From: Paul Cann
Sent: 19 January 2018 15:59
To: Planning.Responses
Subject: RE: Planning Consultation on AL/3/18/DOC

APPLICATION NO: AL/3/18/DOC

Site Address: The Coach House Norton Lane Norton Aldingbourne PO20 3NH

Description of Works: Approval of details reserved by condition imposed under AL/139/16/HH relating to condition 3-surface water drainage & 4-schedule & samples of materials & finishes.

<table><tr><td>Drawn By IC</td><td>Scale 1:50</td></tr><tr><td colspan="2">Drawing No. 20037 - BR - 110</td></tr></table>

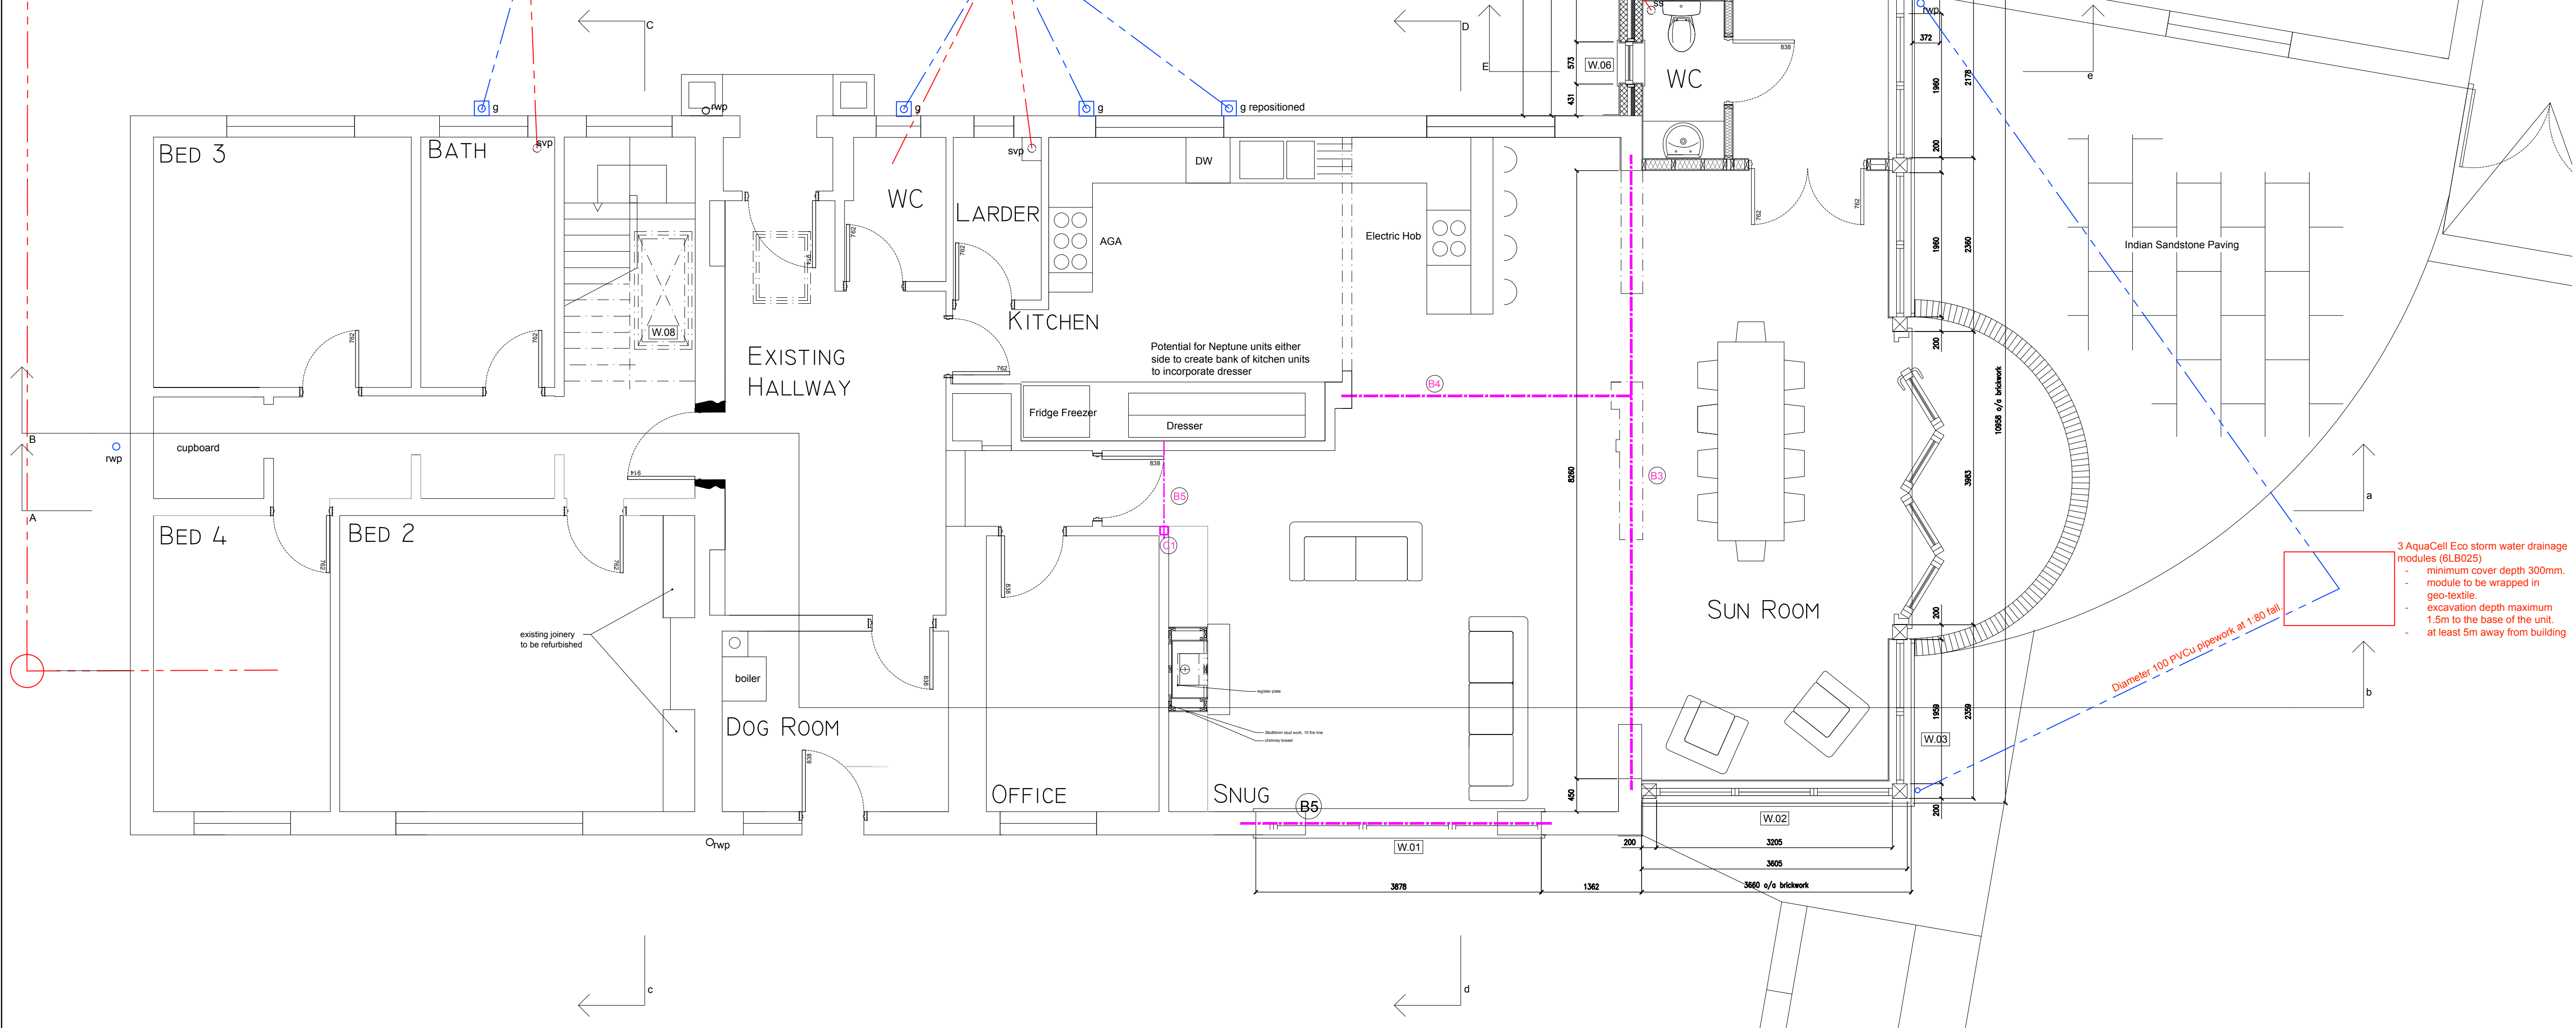
The applicant has provided insufficient details in respect to the surface water drainage design and therefore the condition cannot be discharged. Details required include the following;

1. Winter groundwater monitoring.
2. Winter percolation testing to BRE365 at an agreed depth.
3. Drainage layout including pipe invert levels/soakaway base level, etc.
4. Full construction details of the soakaway.
5. Rainwater pipes to discharge to a catchpit prior to discharge to the soakaway in order to capture silt.
6. Provide construction detail for catchpit.

Items 1 and 2 are critical to the design. The applicant is urged to discuss these requirements with us.
